RE: HOMESTEAD FILING 2 – PRELIMINARY ACCEPTANCE PUNCHLIST FOR FULL SPECTRUM DETENTION POND 1

The El Paso County punchlist from 11/28/2023 site walk identified a few inconsistencies within Pond 1 when compared to the approved construction documents.

24" OUTFALL INTO SAND CREEK
1"=5'

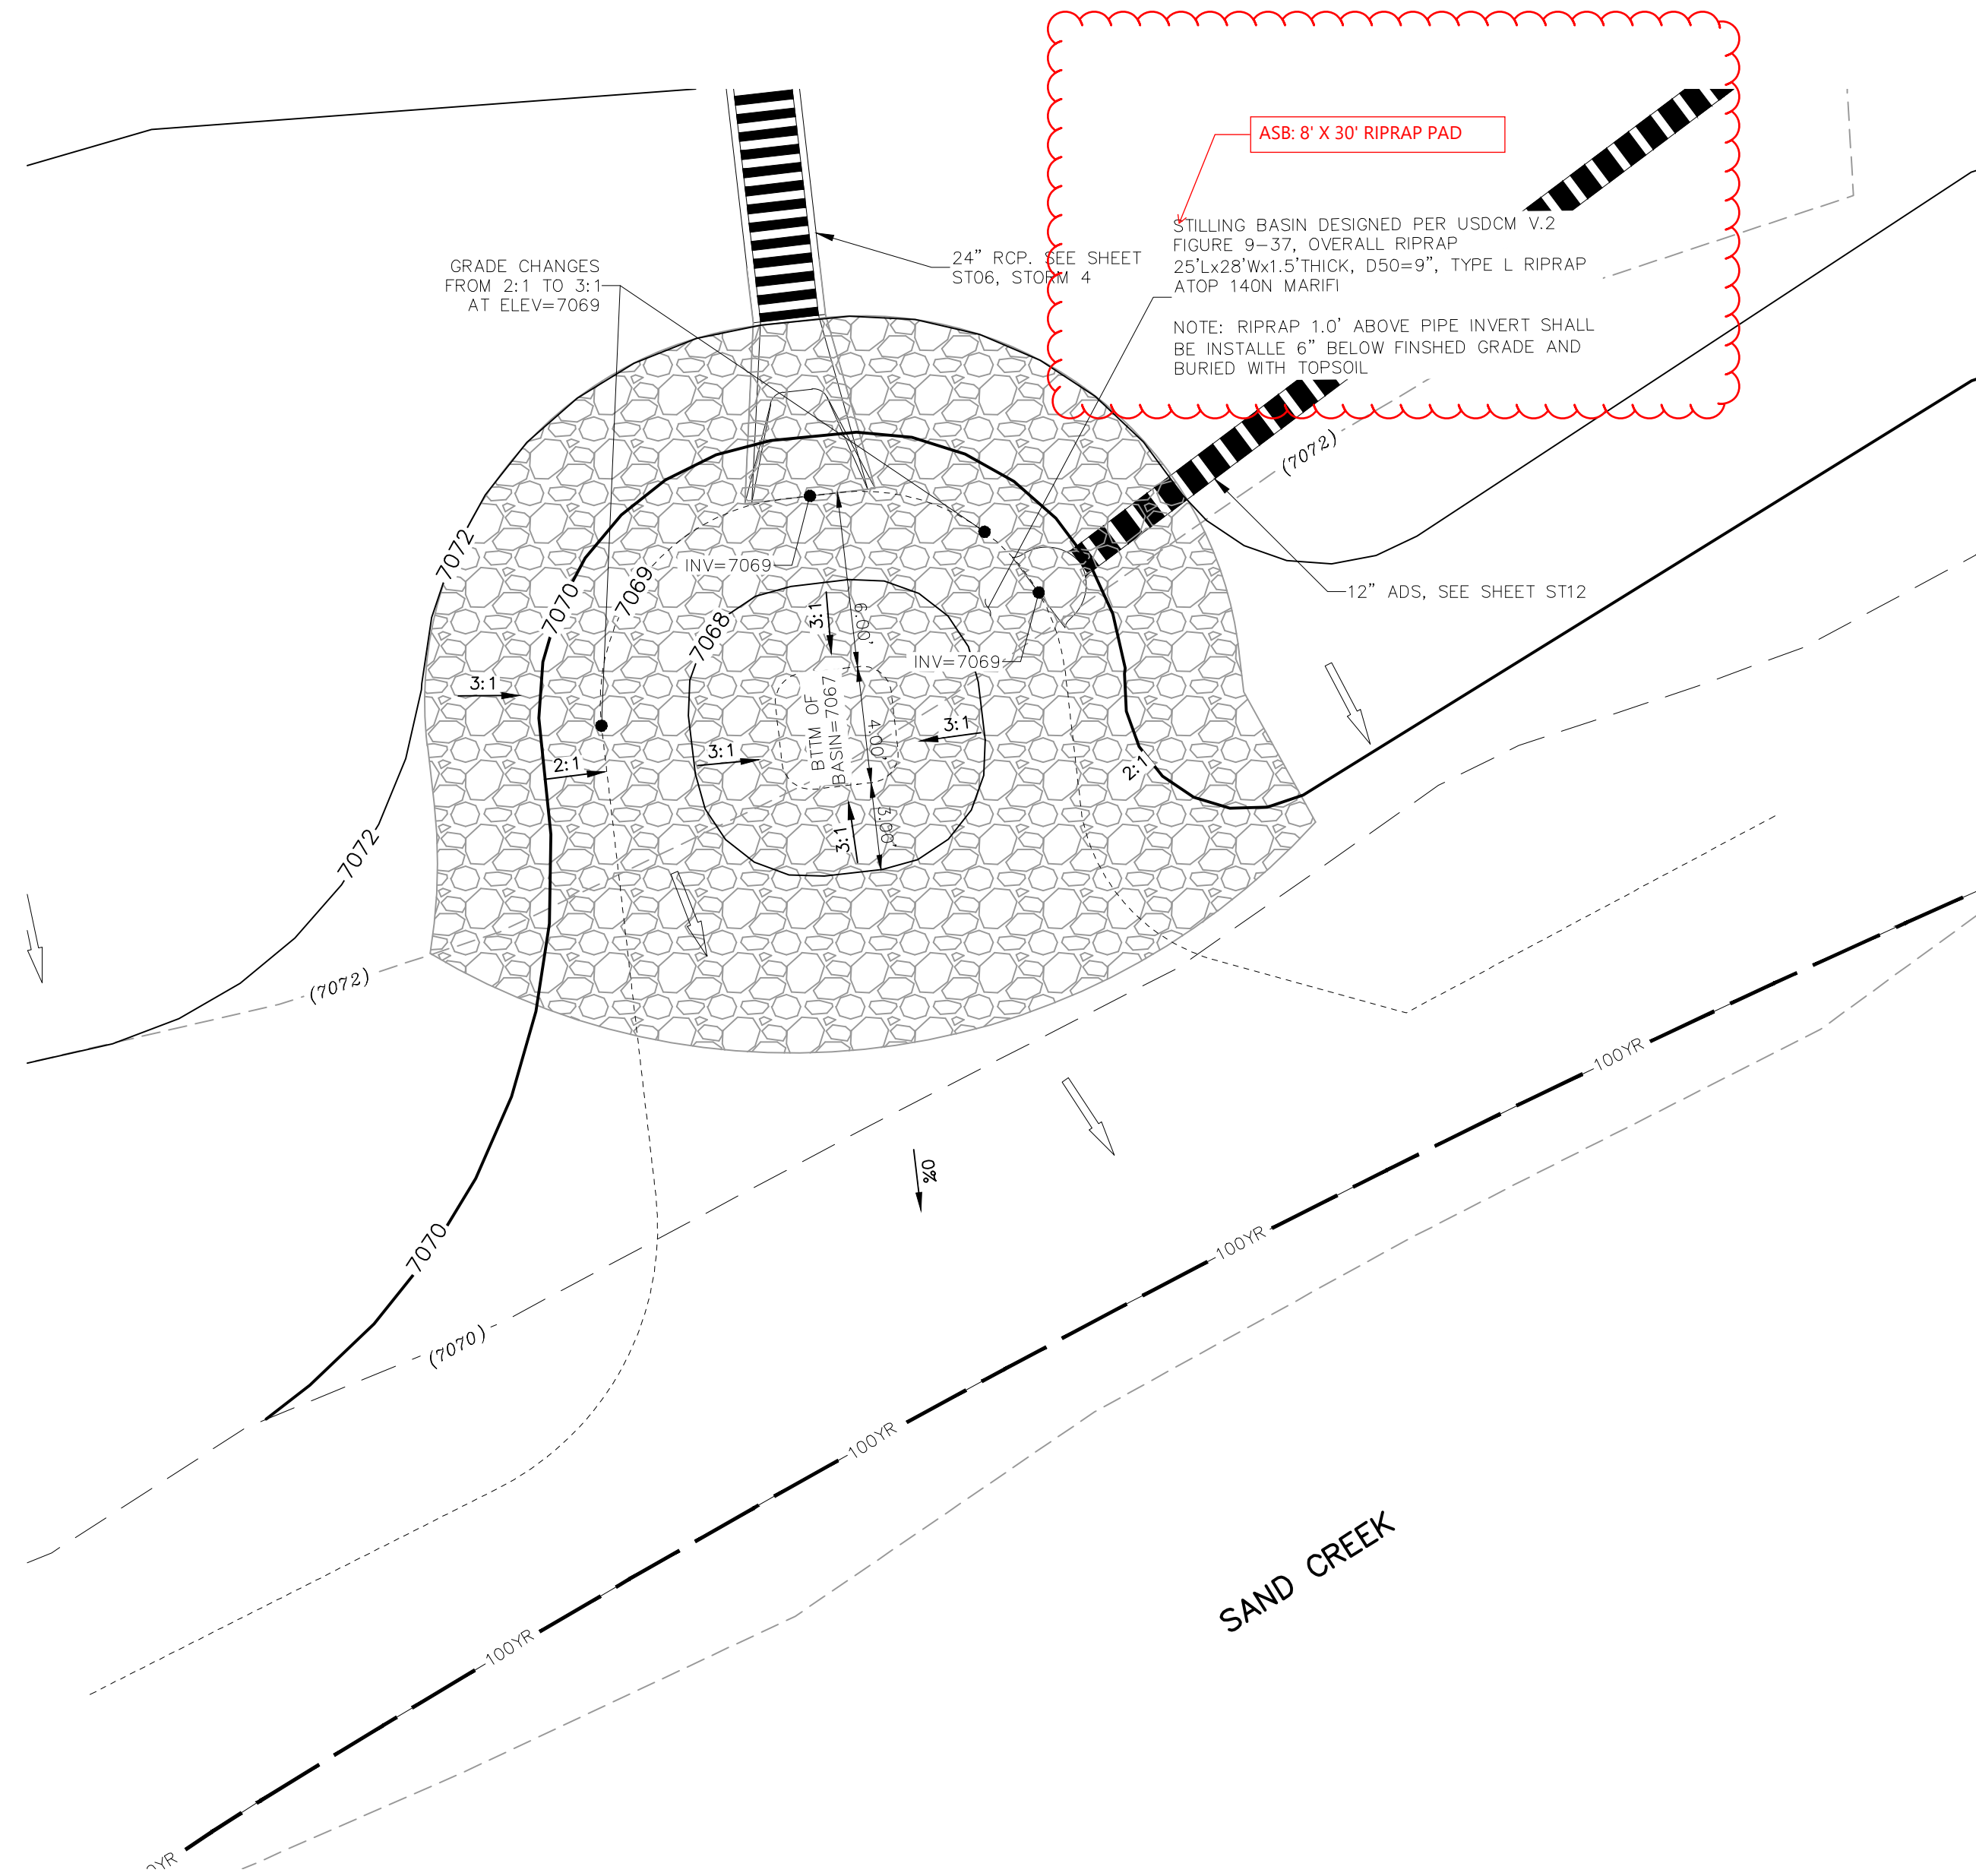
1. Micro screen installed with V-wire bars are horizontal and not vertical
2. Pond outfall not installed per plans. Plunge pool approved, 8' x 30' riprap pad installed.
3. Shown plan riprap around forebay, instead of soil riprap
4. Flat portion of Section A-A (spillway) is installed at less than 20 ft wide.

The pond outfall was constructed with an 8' x 30' Type L riprap pad. The riprap pad provides the necessary energy dissipation for the pond outfall. See attached riprap sizing for verification. Therefore, I recommend that the riprap pad be accepted as the Pond 1 outfall erosion protection
